Engineers comments in respect to surface water drainage and land drainage below. Please note these comments also relate to relevant conditions on F/6/20/DOC, but since they are all related, the comments have been amalgamated together.

APPLICATION NO: F/9/20/DOC

Site Address: Wicks Farm Ford Lane Ford BN18 0DF

Description of Works: Approval of details reserved by condition imposed under ref F/30/18/PL relating to Condition No 3 - surface water drainage.

PRIVATE MANHOLE DETAIL TYPE W (WITH CATCHPIT)
DEPTH FROM COVER LEVEL TO SOFFIT OF PIPE 1.0m - 1.5m
INTERNAL CHAMBER DIAMETER 1500mm*
MAX. SEWER DIAMETER 375mm
(SCALE 1:25)

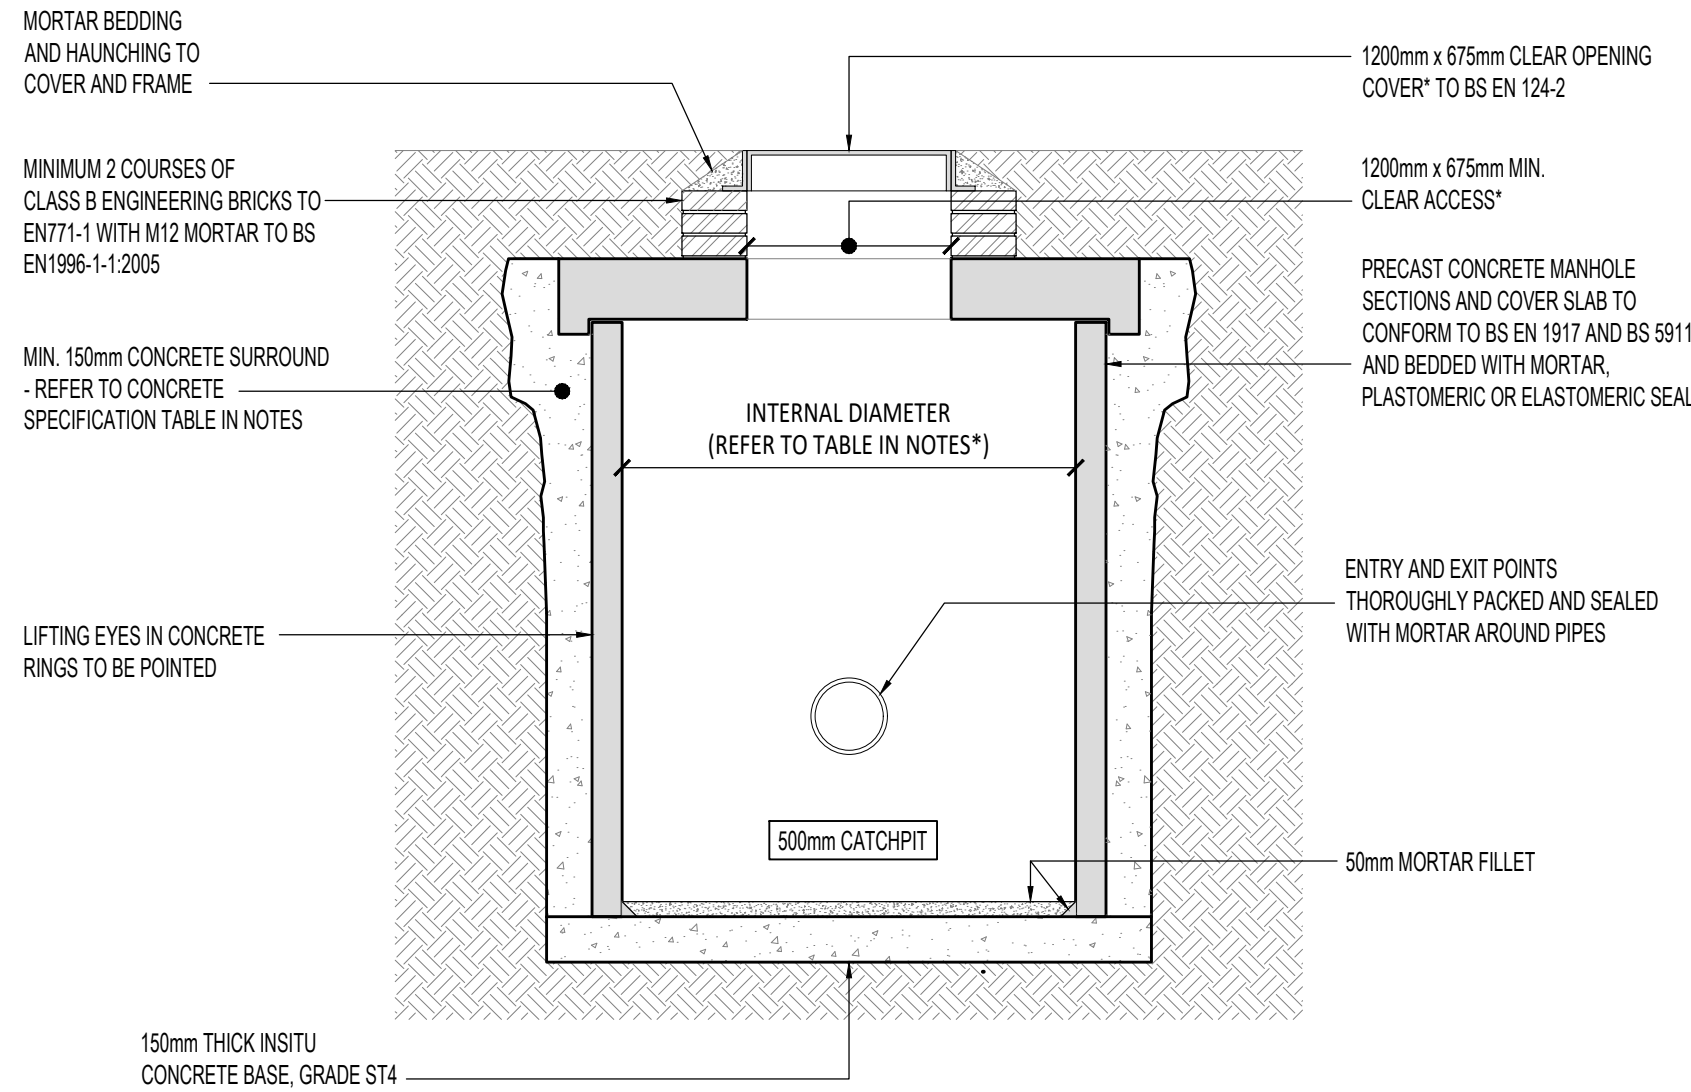
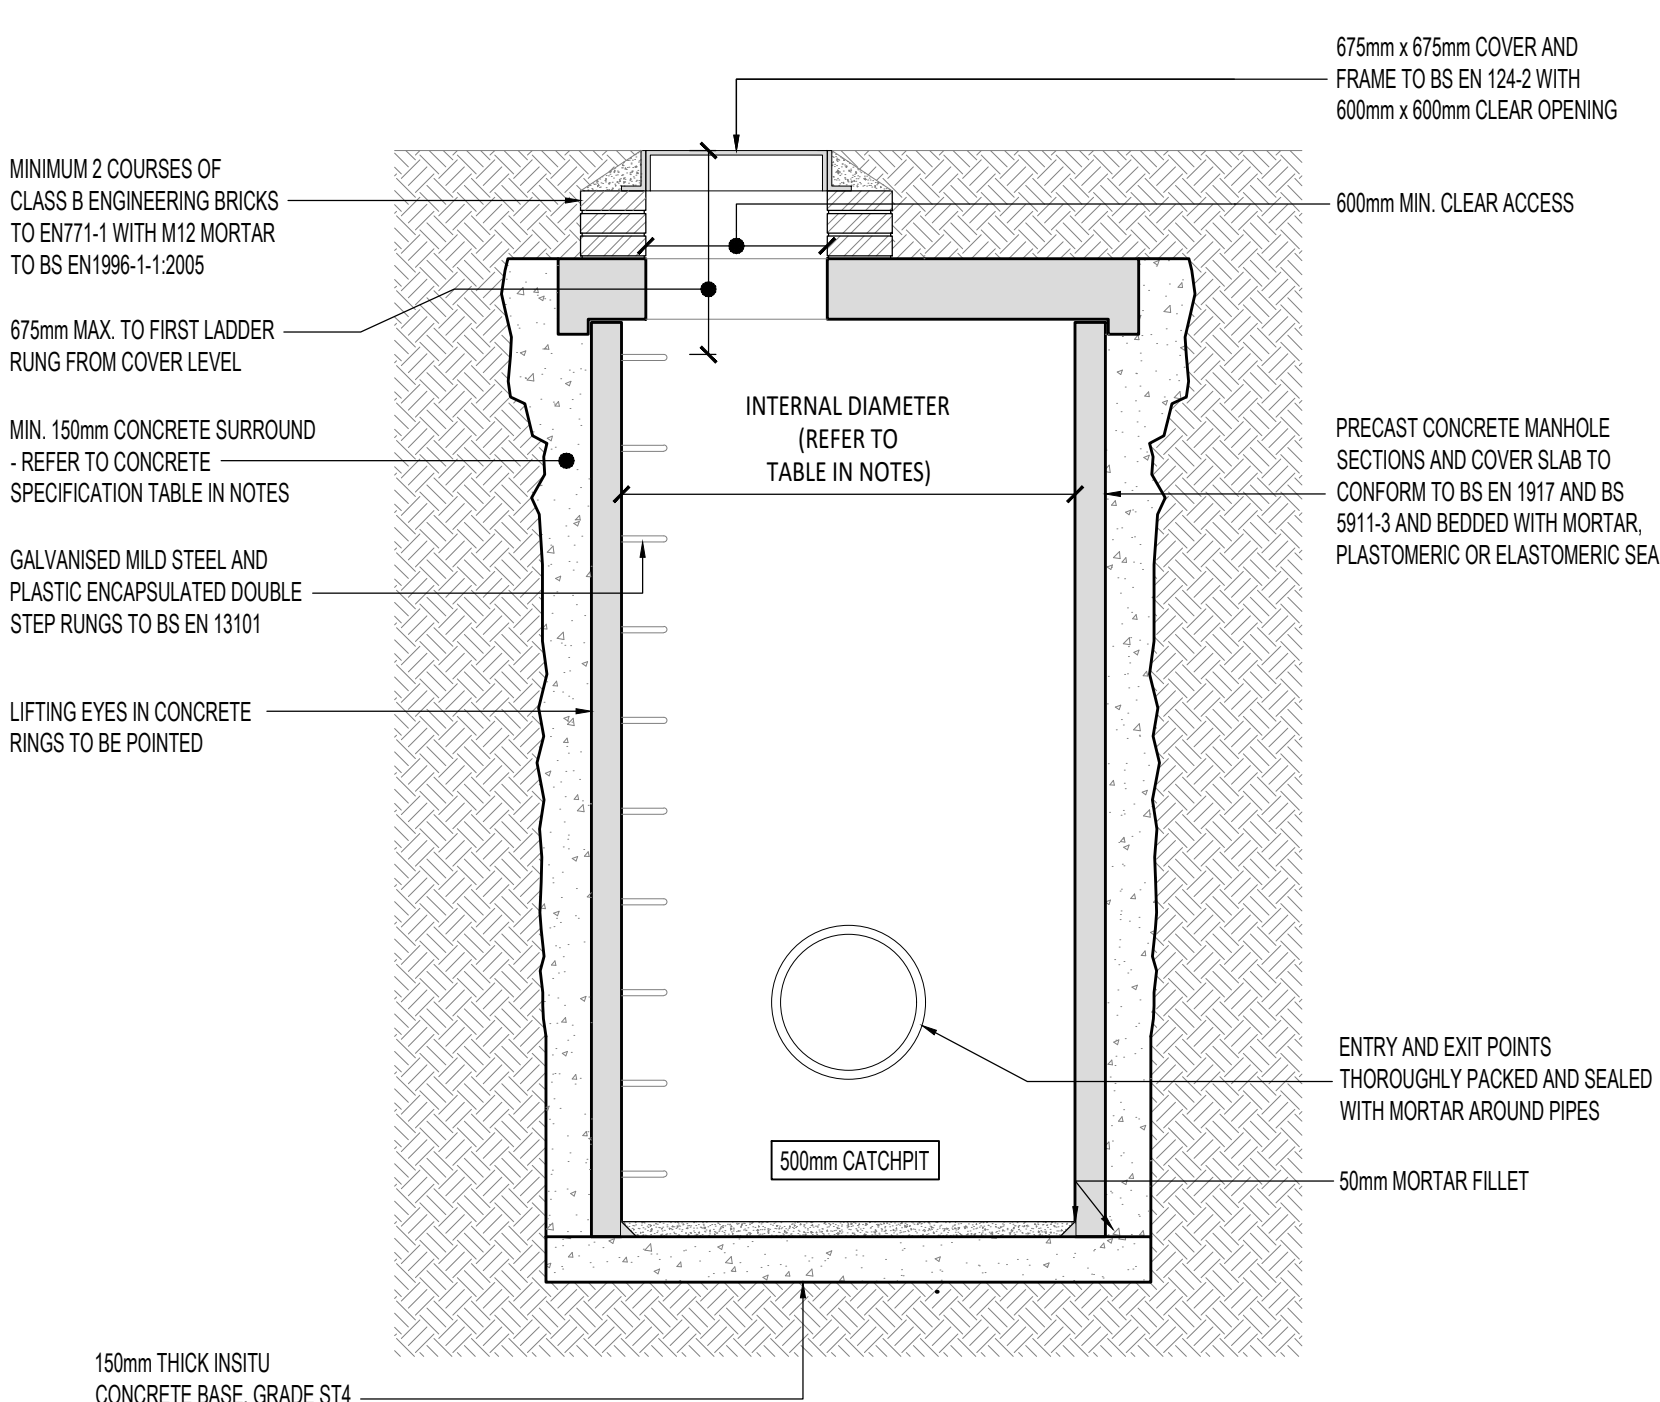
12. Catchpit type W detail – include step rungs for access.
13. Reservoir outlet is at very steep gradient and connecting at 90 degrees to the hydrobrake. Resultant flows could affect the performance of the hydrobrake – could this arrangement be revised to improve the situation.

TYPICAL PIPE BEDDING AND TRENCH DETAILS

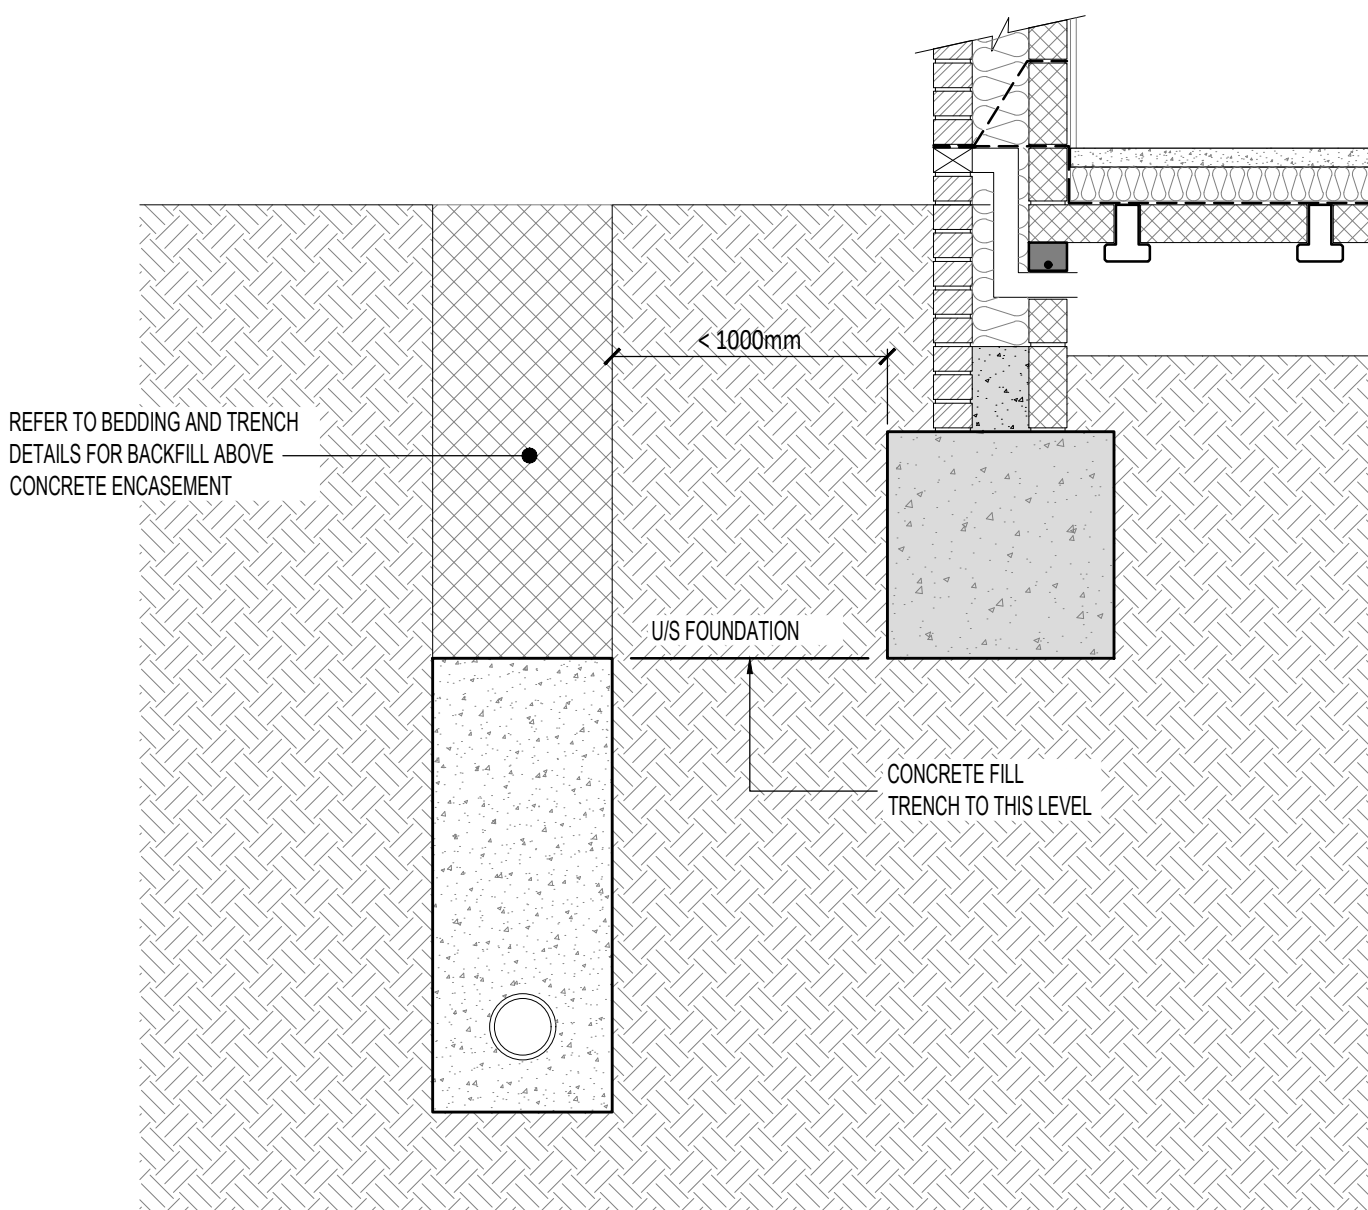
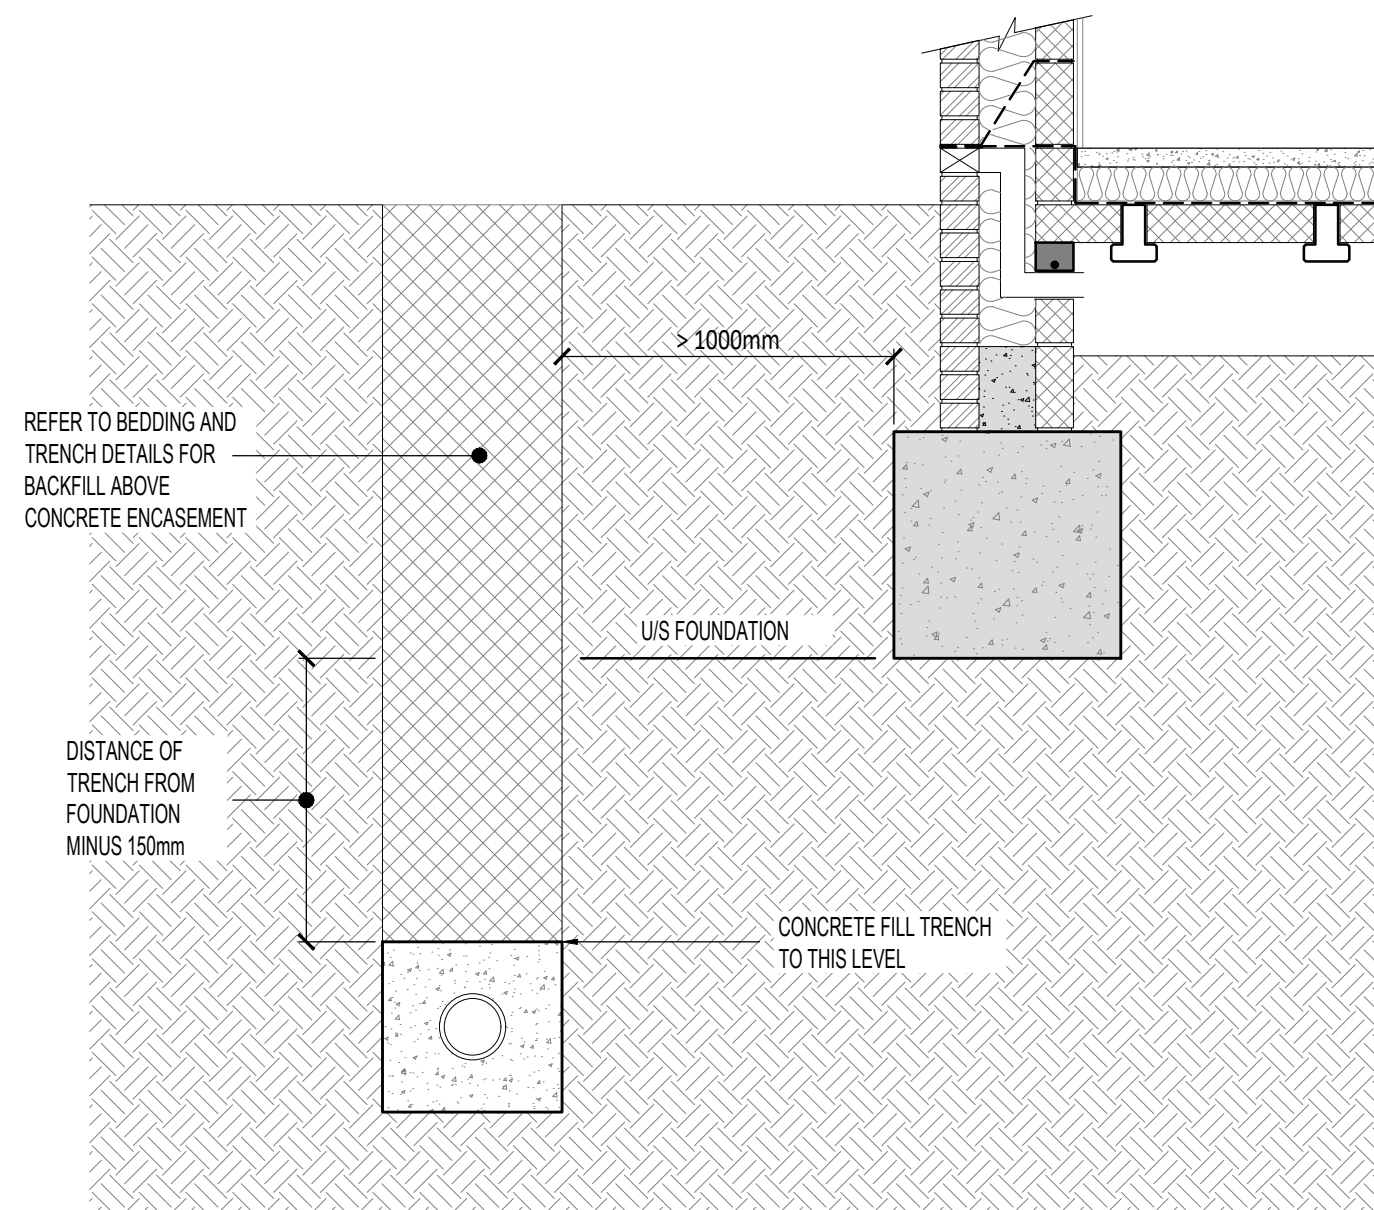
16. Incoming 225mm pipe to swale 2 – provide min. 100mm freeboard between swale bed and pipe invert.
17. Pipe concrete bed and surround detail – specify the specific concrete mix on the detail itself.
